Drawing Title
**FIGURE 10.1
KINGSWAY JUNCTION
GEOLOGY & SOILS STUDY AREA &
FEATURES**

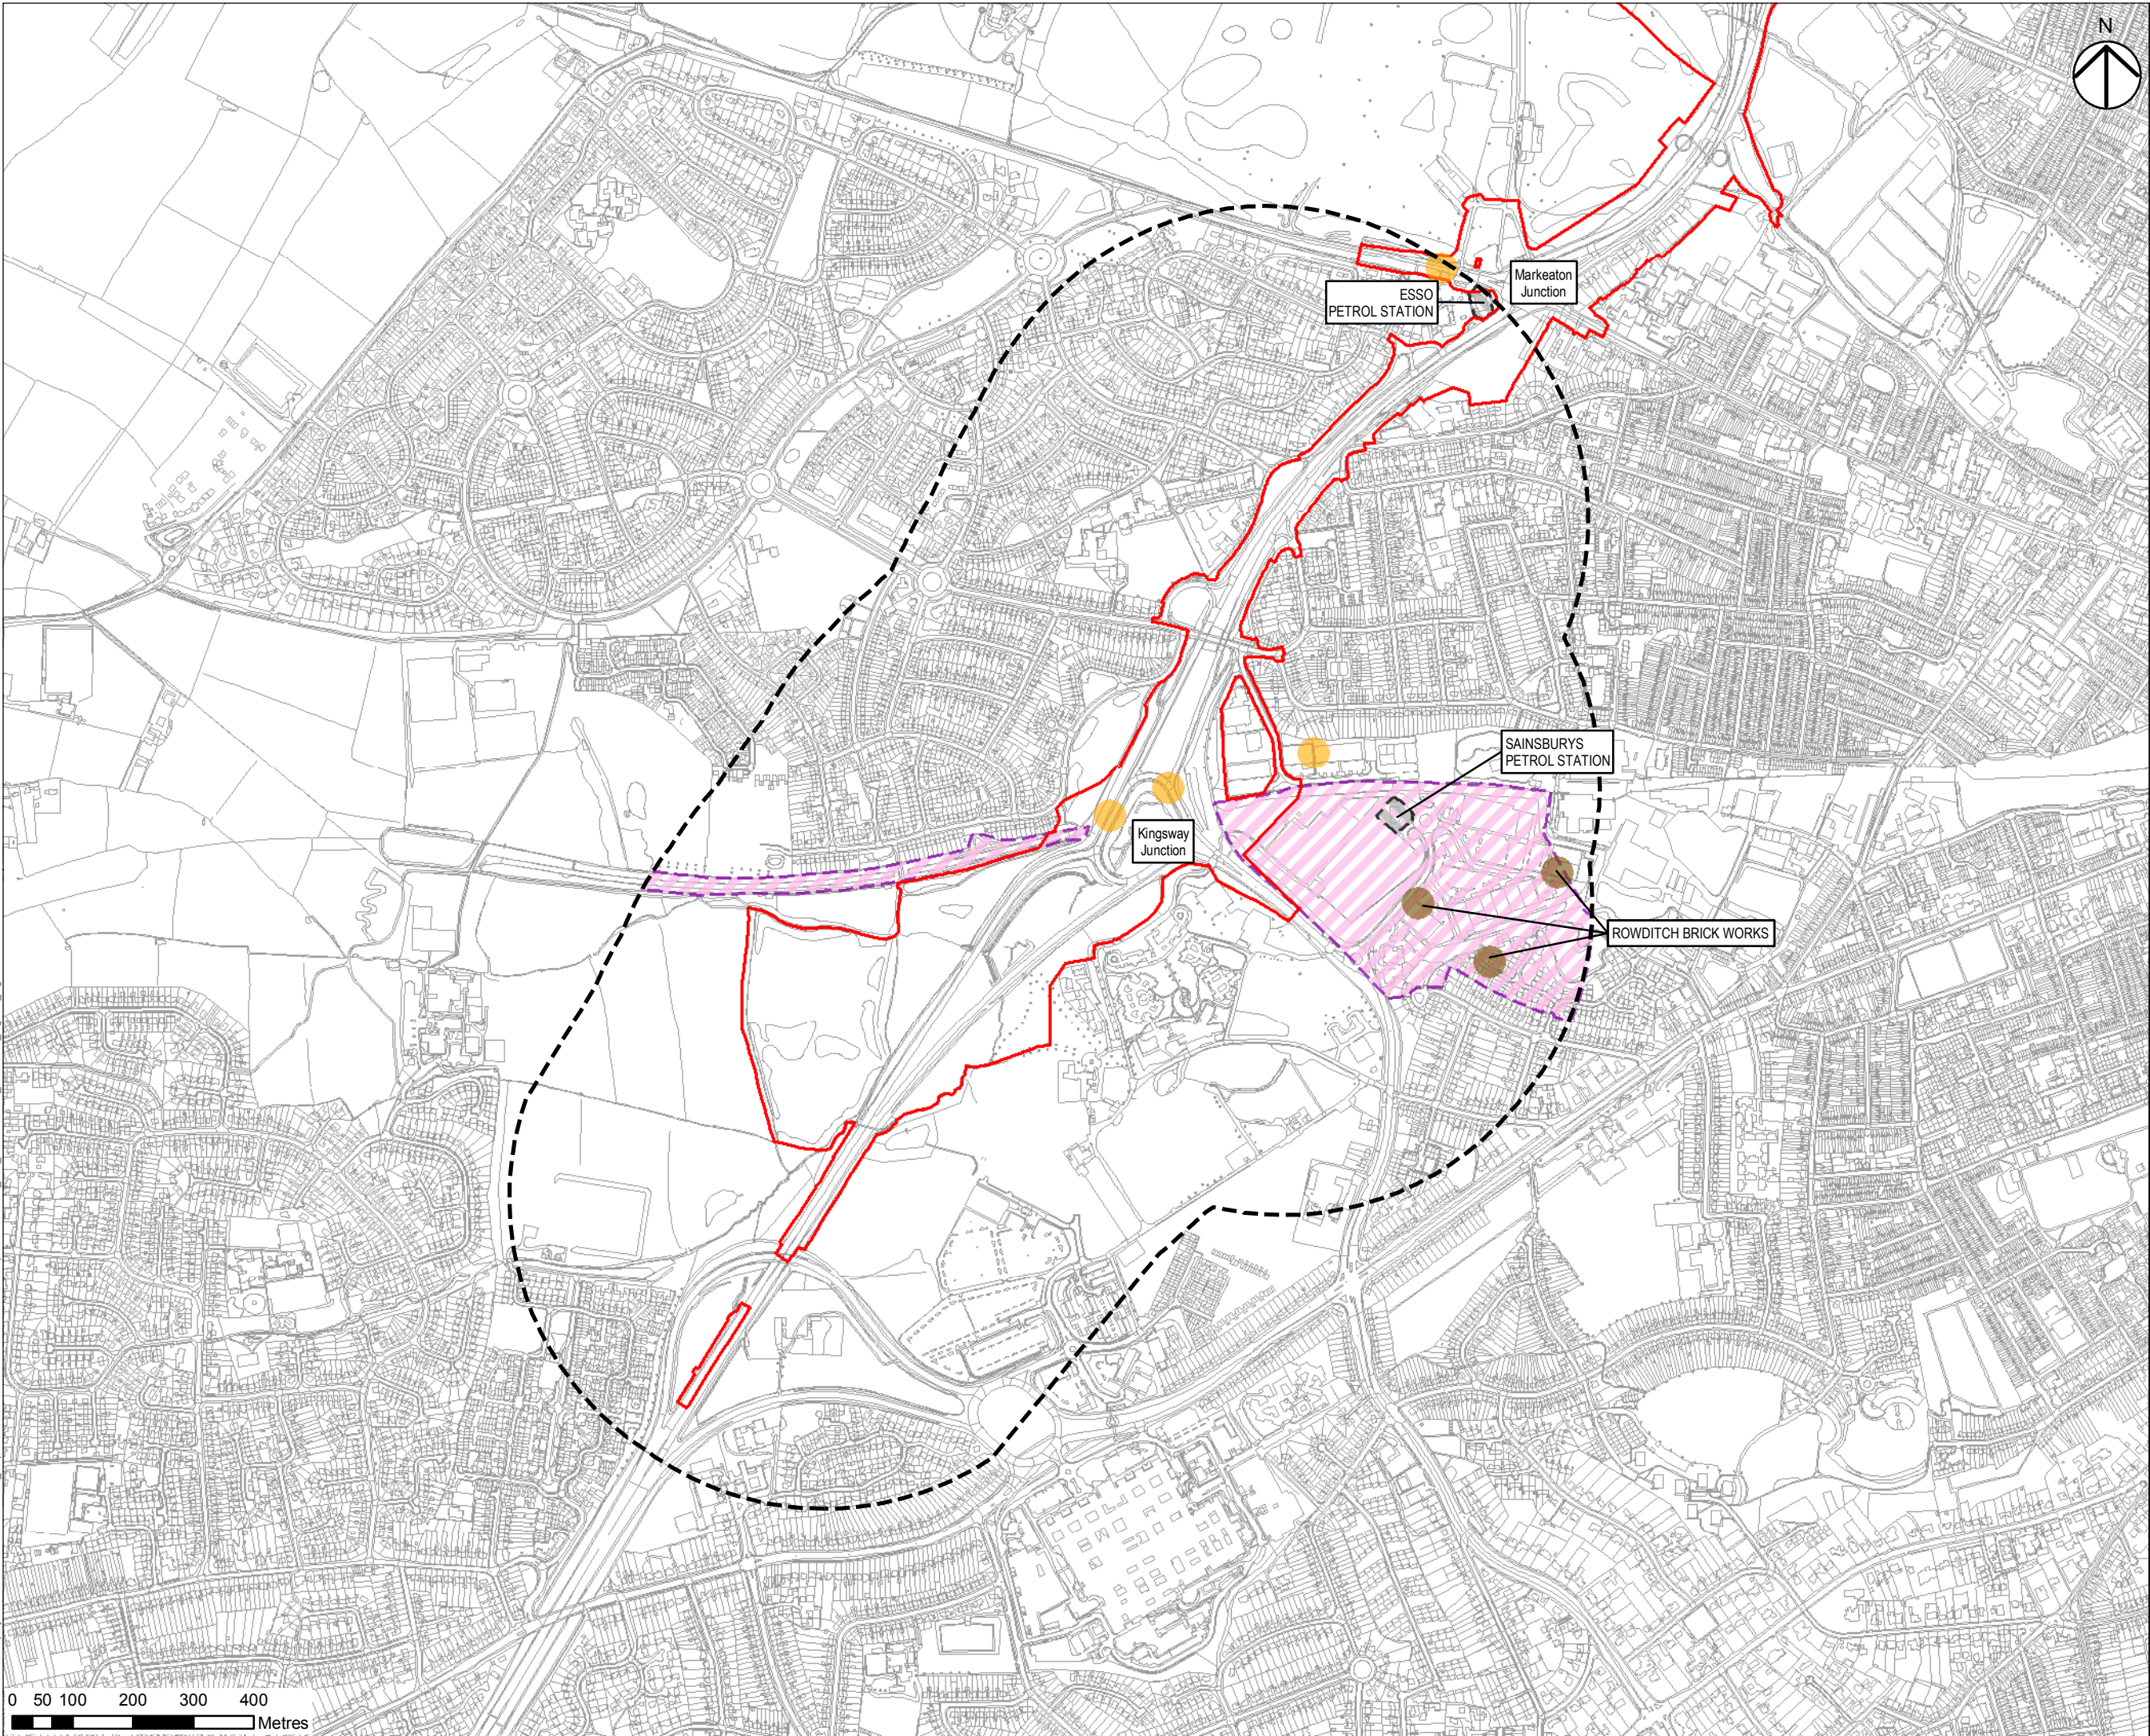
Q47 HE response to Q16 -Proposals at Kingsway Junction include wetland habitats, Have calculations been made as to how much methane from the uncapped Kingsway landfill, will be emitted through the water?

Q48 HE response to Q18 – Have the scheme effects on water quality taken account of the increased pollution from uncapping Kingway landfill run-off ? See also FOE Q31, Q32,Q33,Q34; 3 A38

Q49 HE response to Q18 – 'Scheme would have a 'neutral effect on surface water quality” yet the PEIR (Human Health Risk Assessment 9.5.32) clearly states a risk from chromium hexavalent, copper, cyanide, lead, nickel, zinc and ammoniacal nitrogen at Kingsway Junction. How can this be a 'neutral effect'?
